Reference No:	2023/62/93088/W
Site Address:	Hunters Lodge, Cemetery Road, Holmfirth, HD9 2RH
Description:	Erection of two storey side extension
Recommending Officer:	William Simcock

DECISION – Conditional Full Permission

Officer Report 2023/93088
Hunter's Lodge, Cemetery Road, Holmfirth

client	MR A NUTTON		
project	PROPOSED EXTENSION TO HUNTERS LODGE, CEMETERY ROAD, HOLMFIRTH		
drawing	PROPOSED PLANS AND ELEVATIONS		
revision	notes	date	drawn
*	*	*	*
scale :	1:50 & 1:100 AT A1	11.22	PB
project no.	drawing no.	revision	
2246	02

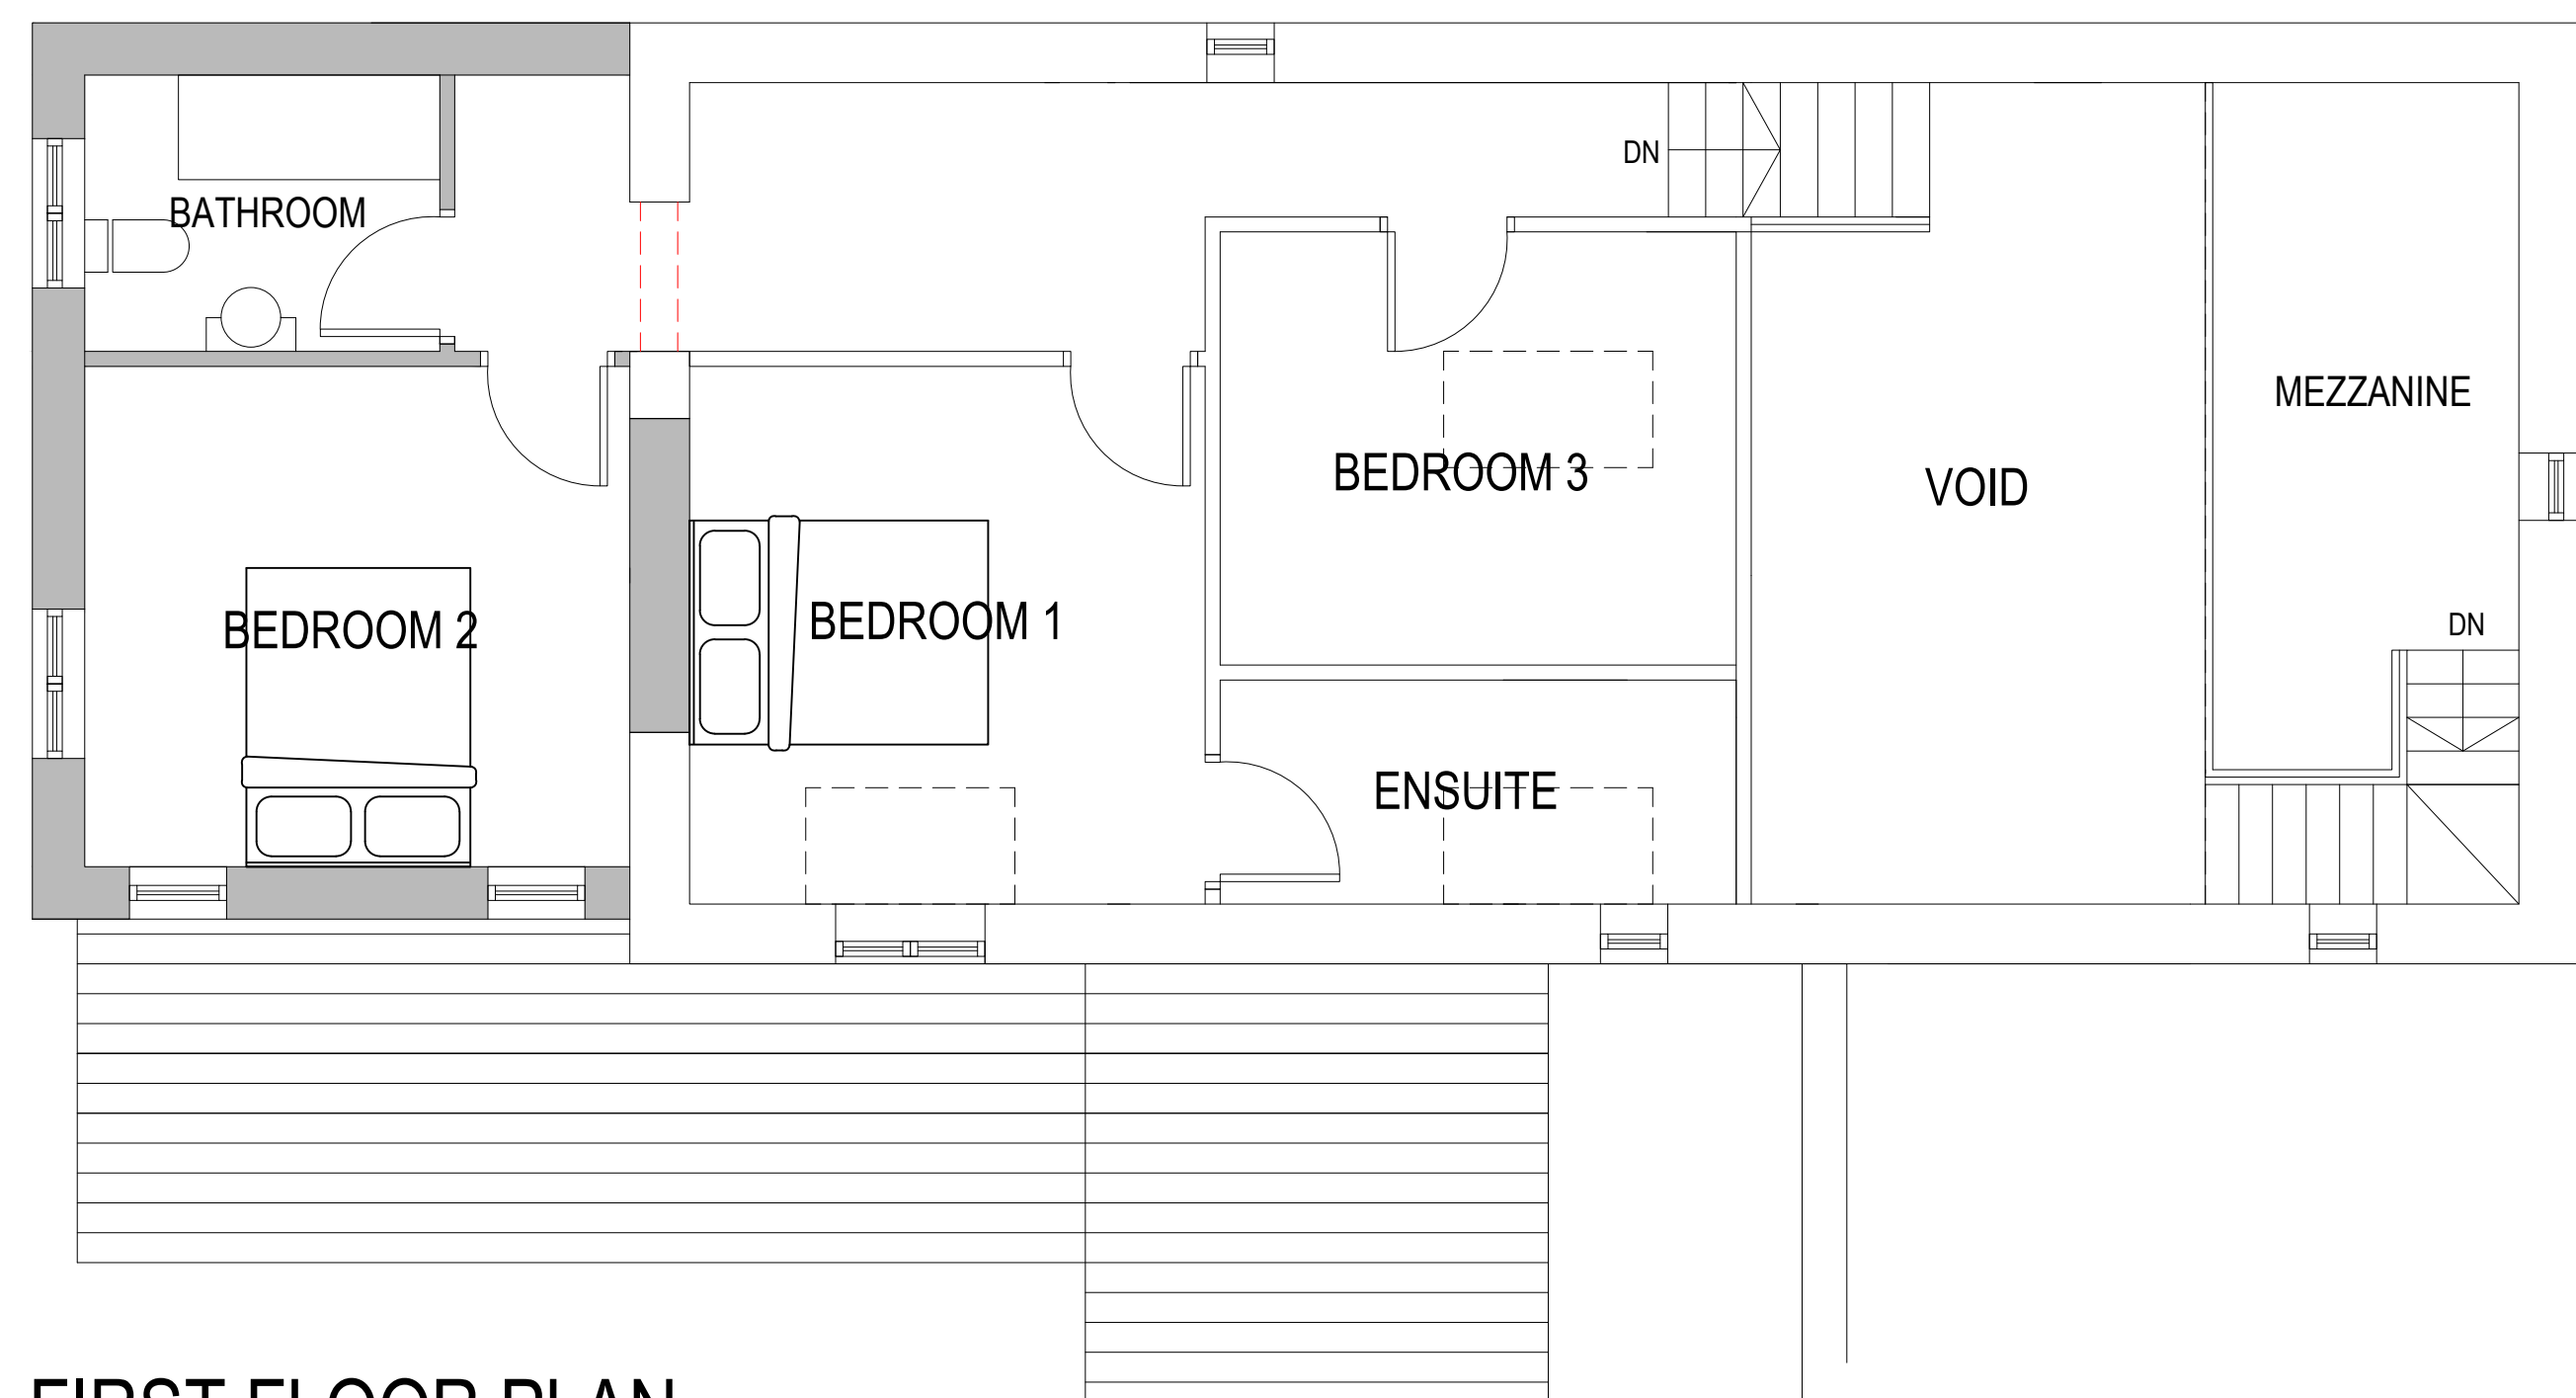
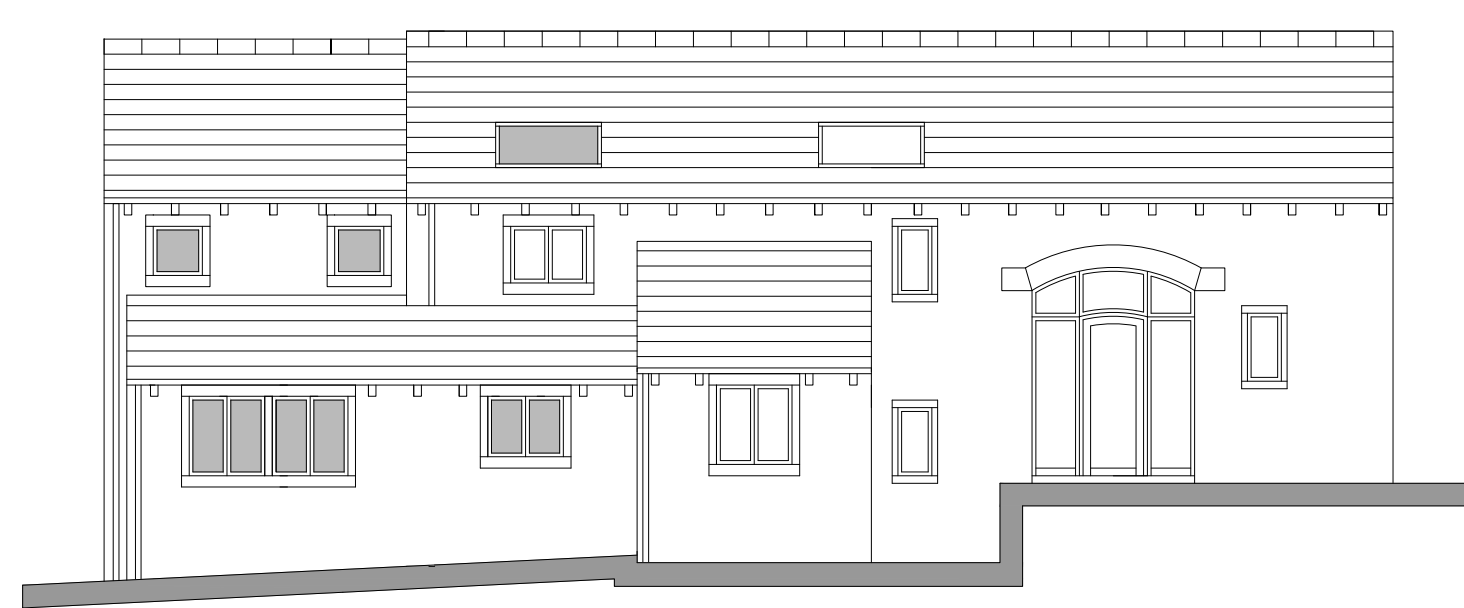
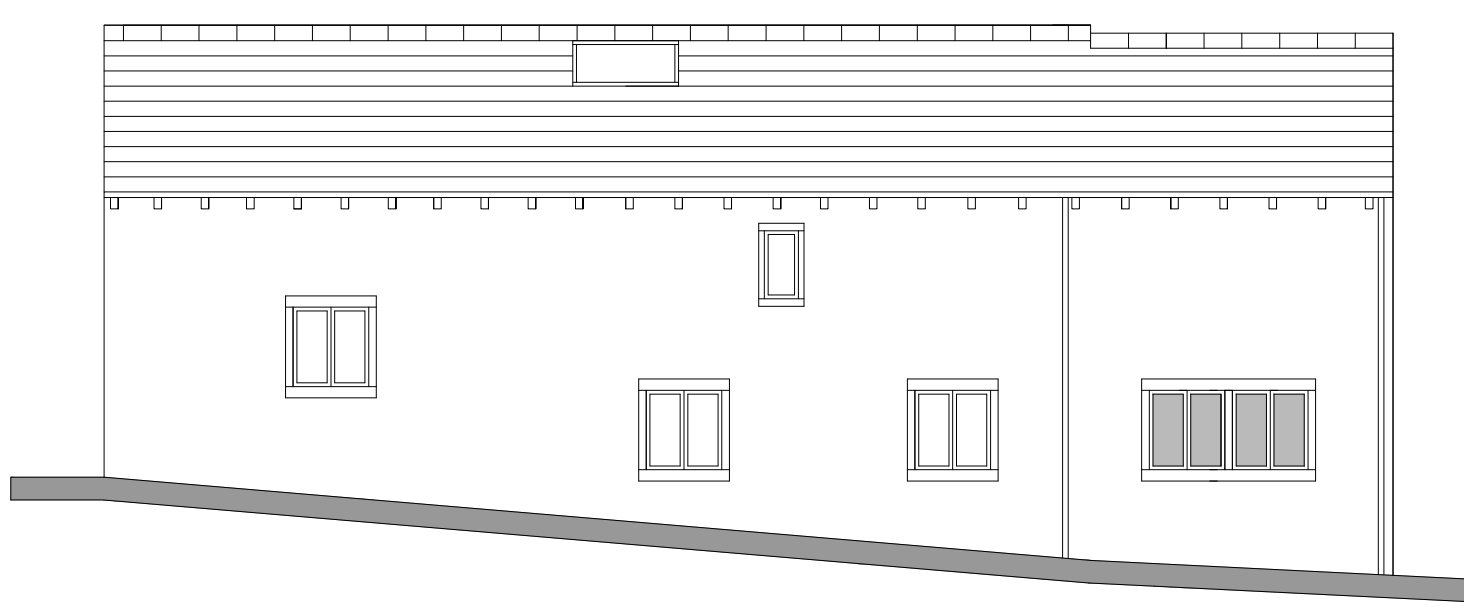
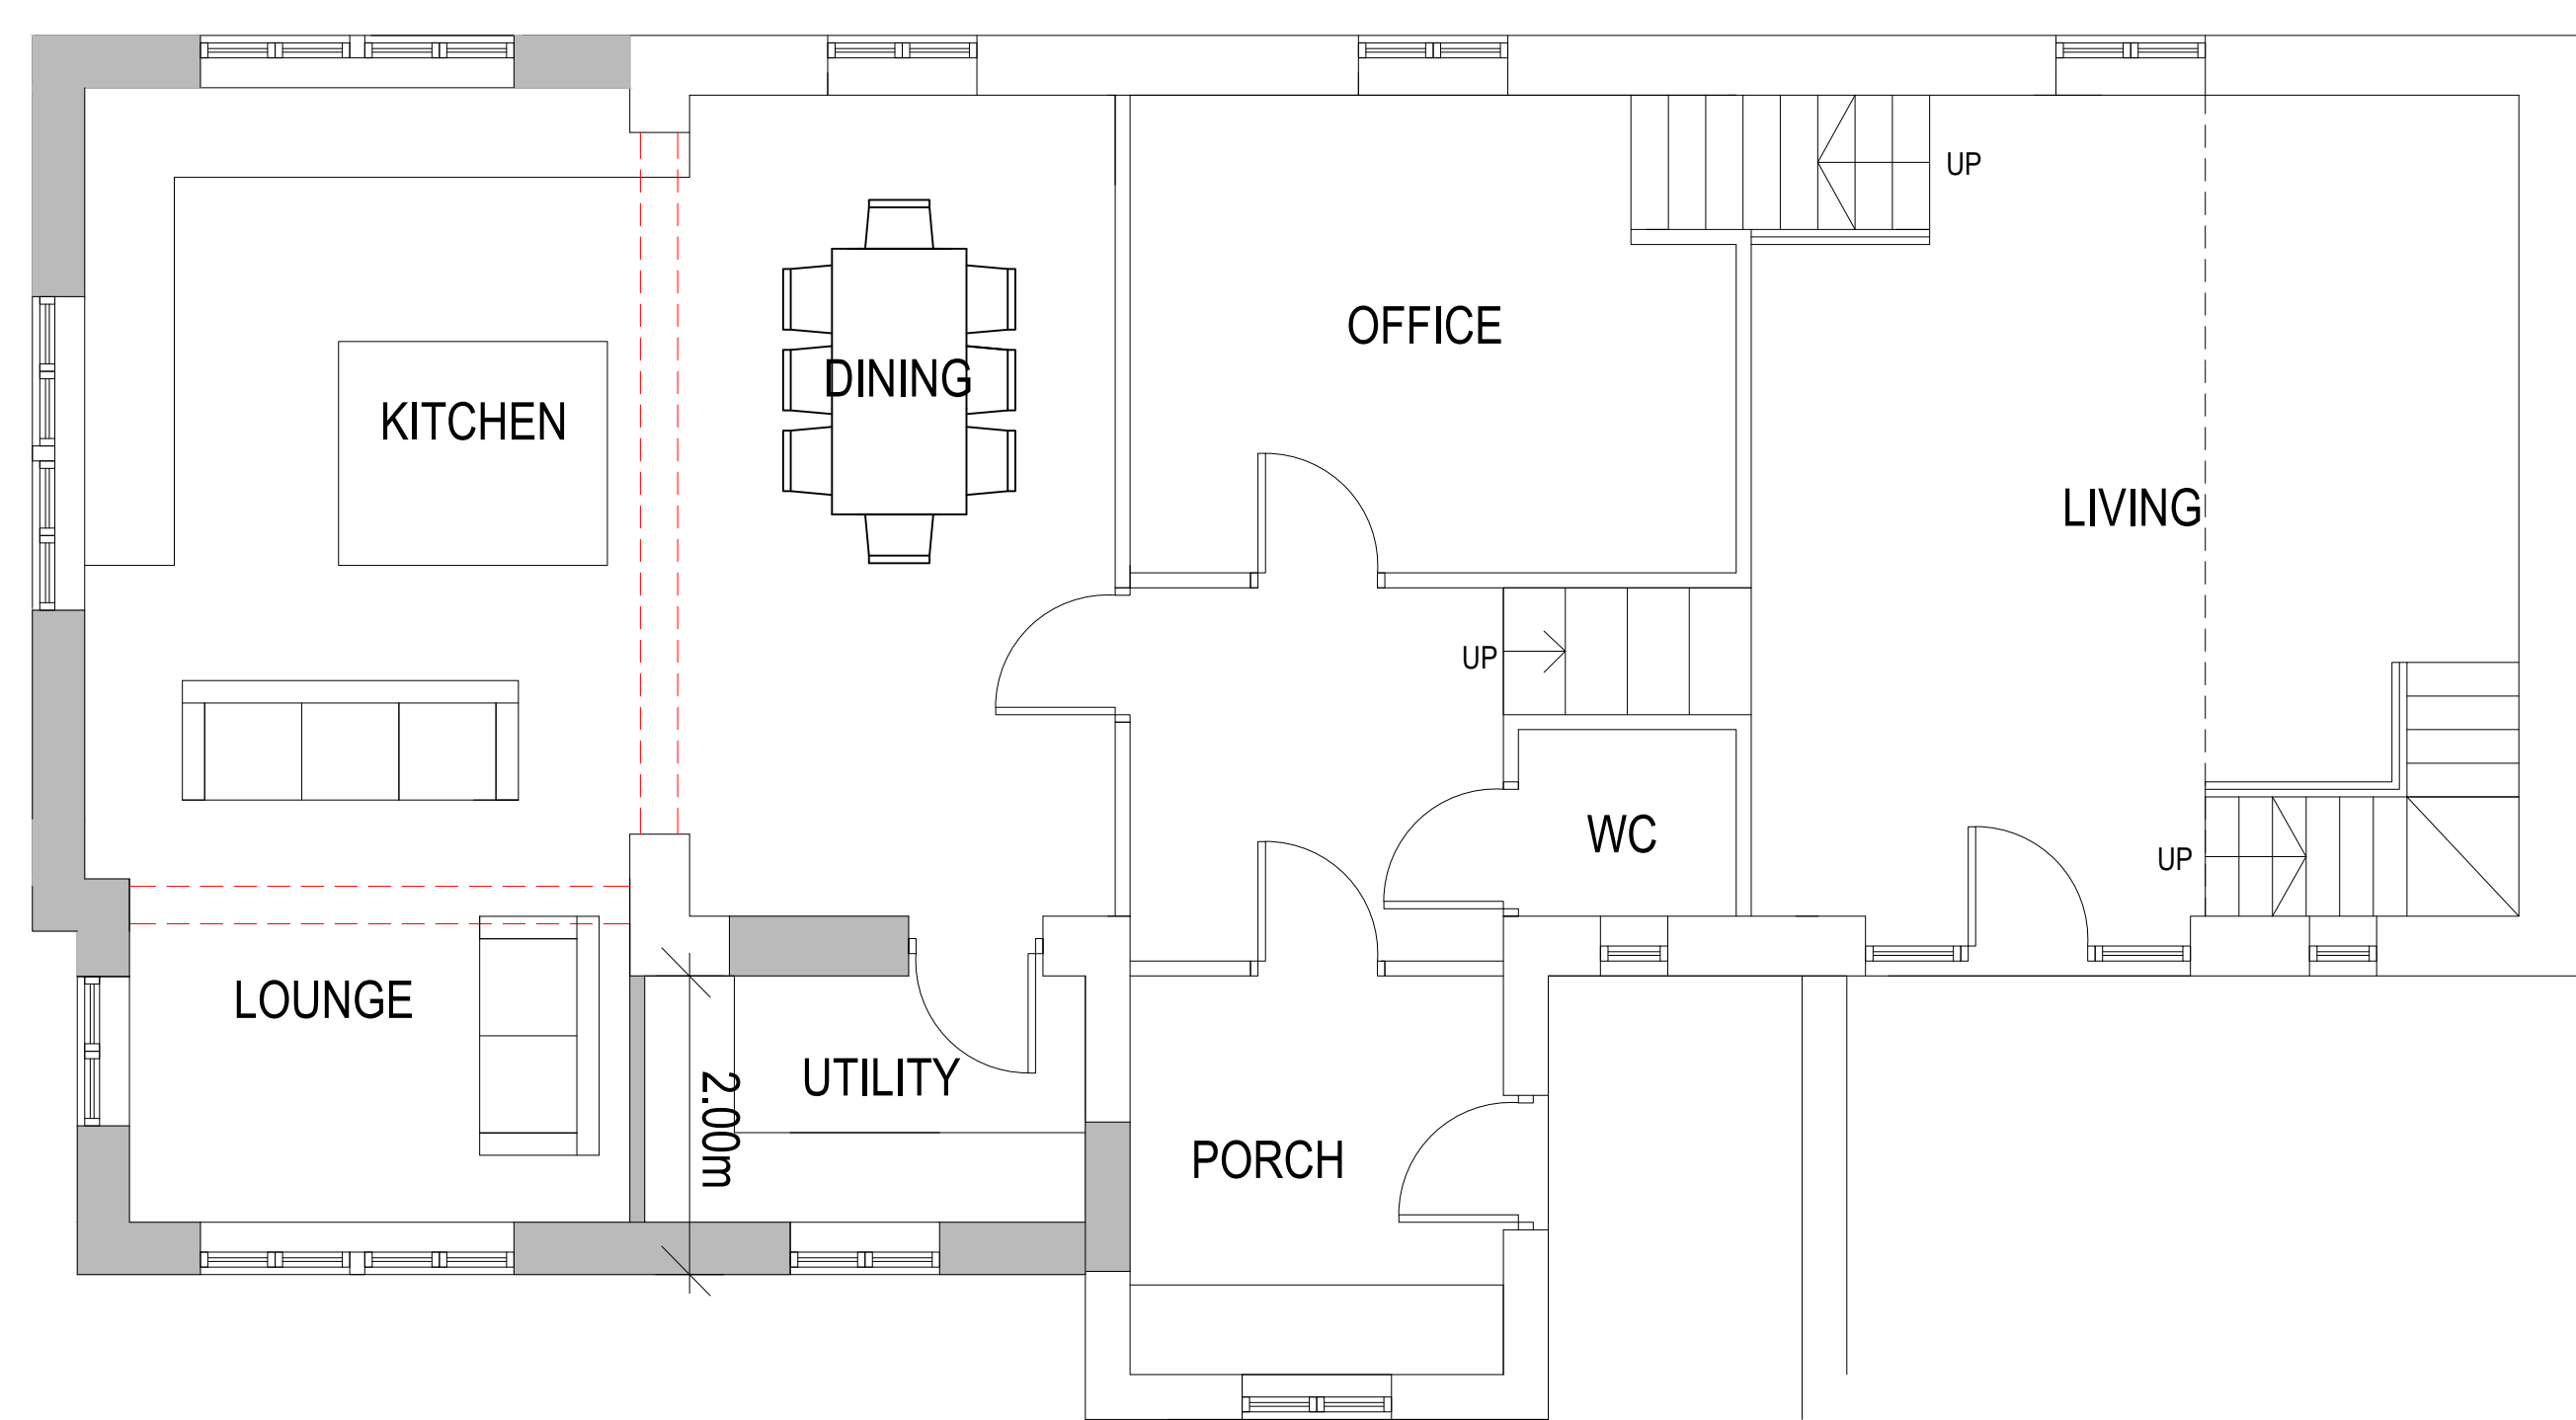
A single-storey extension that originally formed part of the proposals has been deleted.

05-Dec-2023 – The single-storey element was deleted from the proposal and the two-storey element retained.

The scheme as originally submitted involved an extension to the front, and it is considered that based on the architect’s own figures, this would have given rise to a disproportionate addition. Now that the proposal is being assessed as for a two-storey side extension only, it is no longer considered disproportionate. It would allow the existing building to remain the dominant element both in size and in appearance. The increase in volume is now reduced to a 30.9% increase, just the side extension, or 36.6% with the porch. This would not amount to a disproportionate addition to the original dwelling and the application therefore fully accords with national and local planning policy.
